October 1, 2018

**Re: La Pasada Kitchen Addition**  
**2206 Fourth st. NW ALB 87102**  
**Traffic Circulation Layout**  
Engineer's/Architect's Stamp 08-13-18 (H14D089)

**TCL**

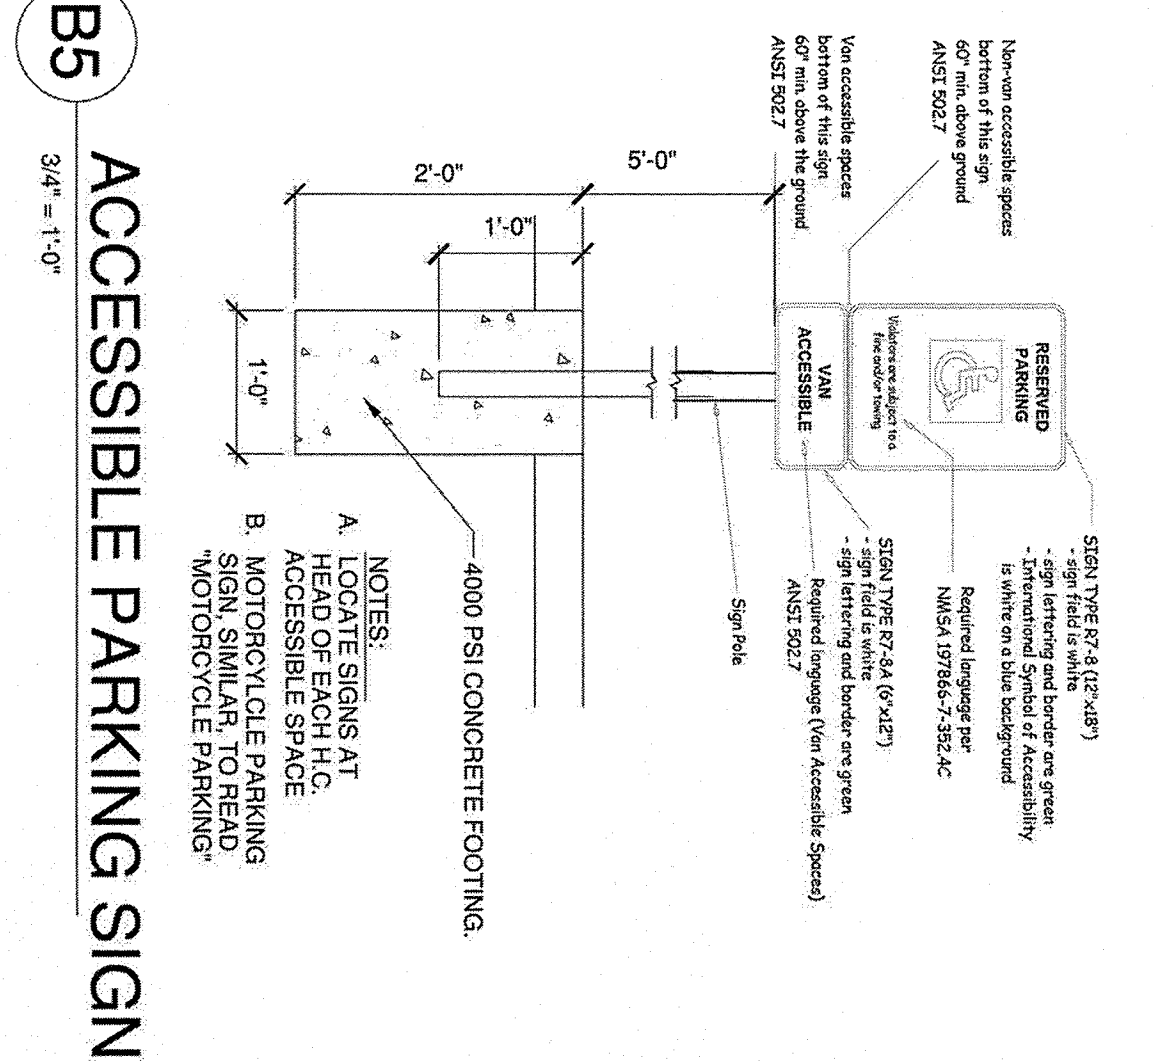
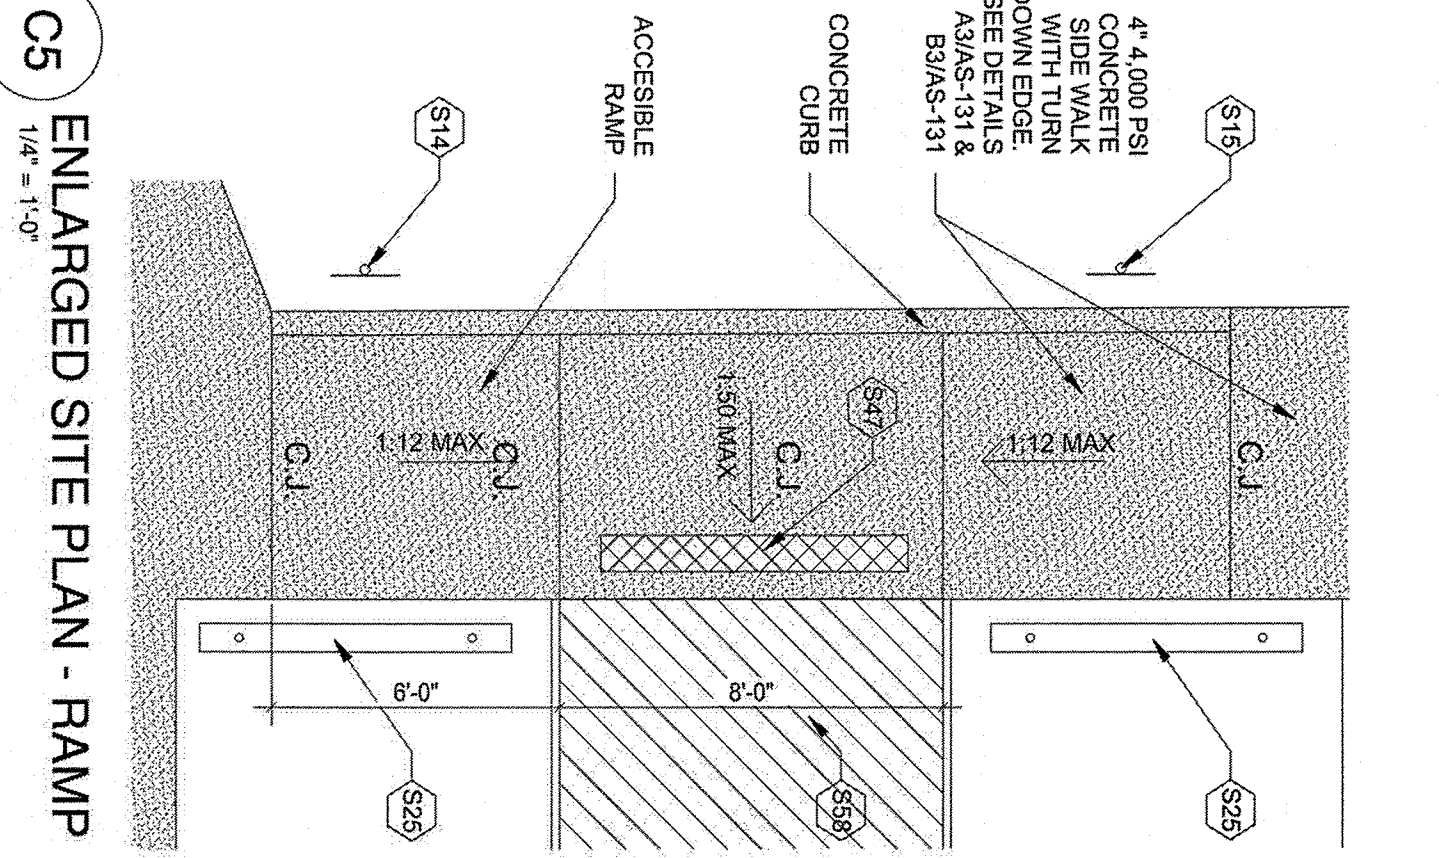
The TCL submittal received 09-27-18 is approved for Building Permit with the condition of adding "NO PARKING" on blue striping next to ADA access, which will be checked for certificate of occupancy. A copy of the stamped and signed plan will be needed for each of the building permit plans. Please keep the original to be used for certification of the site for final C.O. for Transportation.
